Your Ref: OWPC25418
Our Ref: FG/145/19/PL 20-11-2019
Please ask for:
Zac Denton

Demolition of existing detached dwelling and replace with new two storey detached dwelling.

31 South Drive Ferring

Thank you for your internet representation made on 9th January 2020 which has been recorded as **'an objection'** with the comments as follows:

DRWG. TITLE:
PROPOSED ELEVATIONS

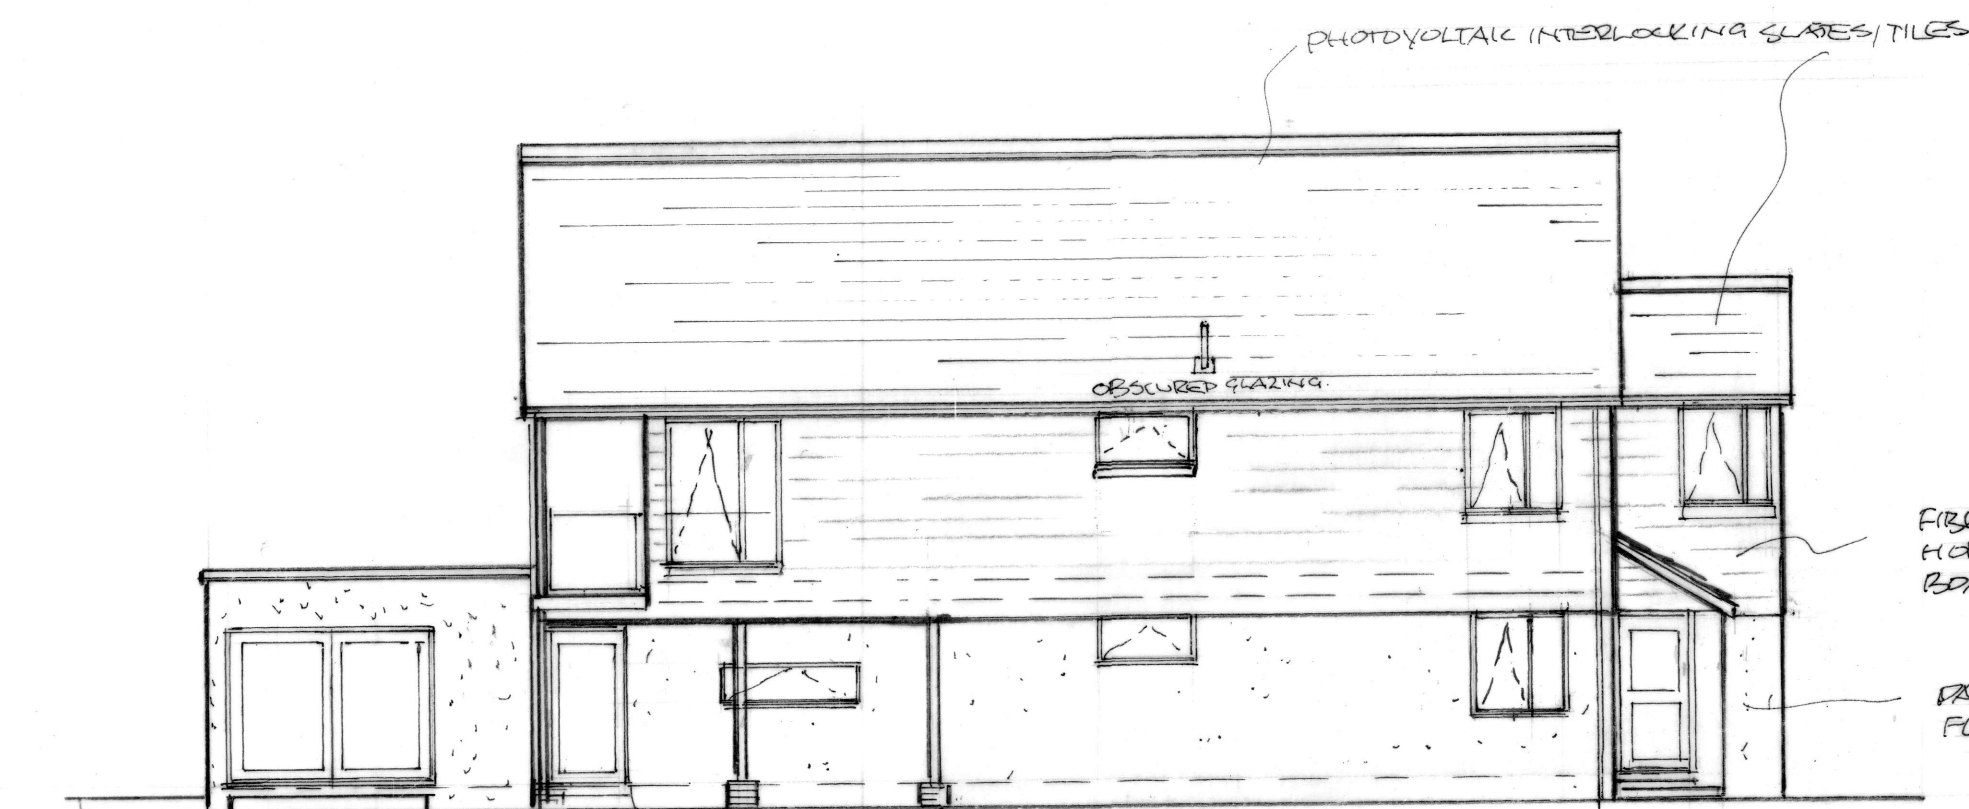
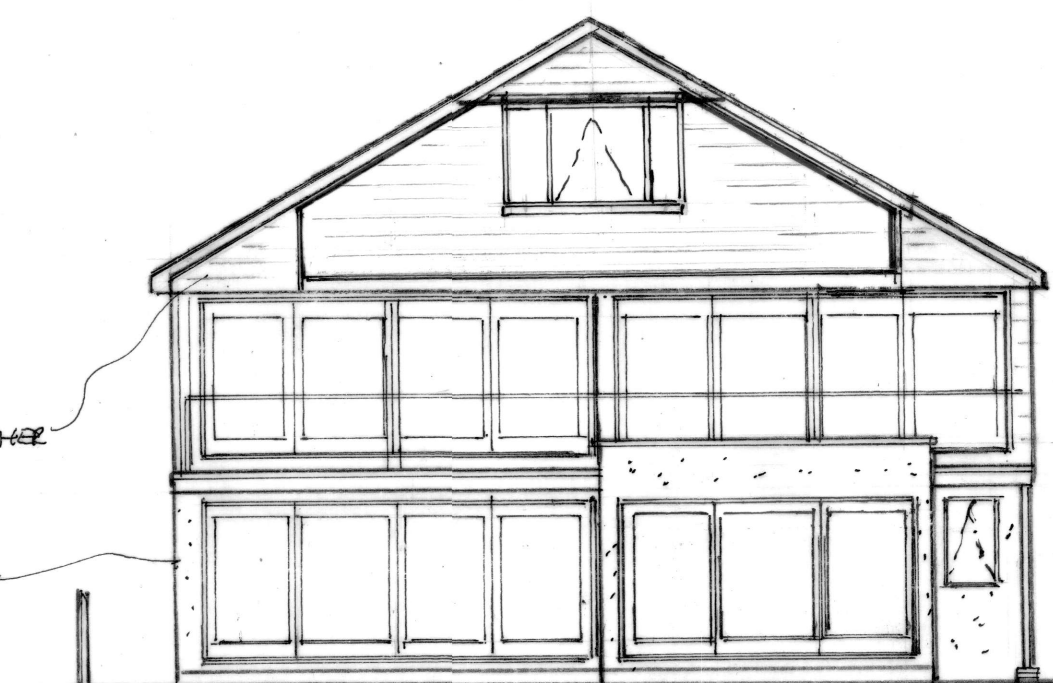
The large roof void shown and the fact that there are windows at high level suggest that this area is intended to become a loft conversion. This will make the property a 3 storey development, not 2 storey as the application states. As such this will be out of keeping with the adjacent properties.

Even without it becoming a loft conversion the design of gable ends with windows will give the building the bulk and appearance of a 3 storey property with the same effect.

As such the property would be very dominating and result in overshadowing and overlooking of the adjoining properties. In addition the high level window on the south elevation in particular would result in a loss of privacy to the neighbouring properties.
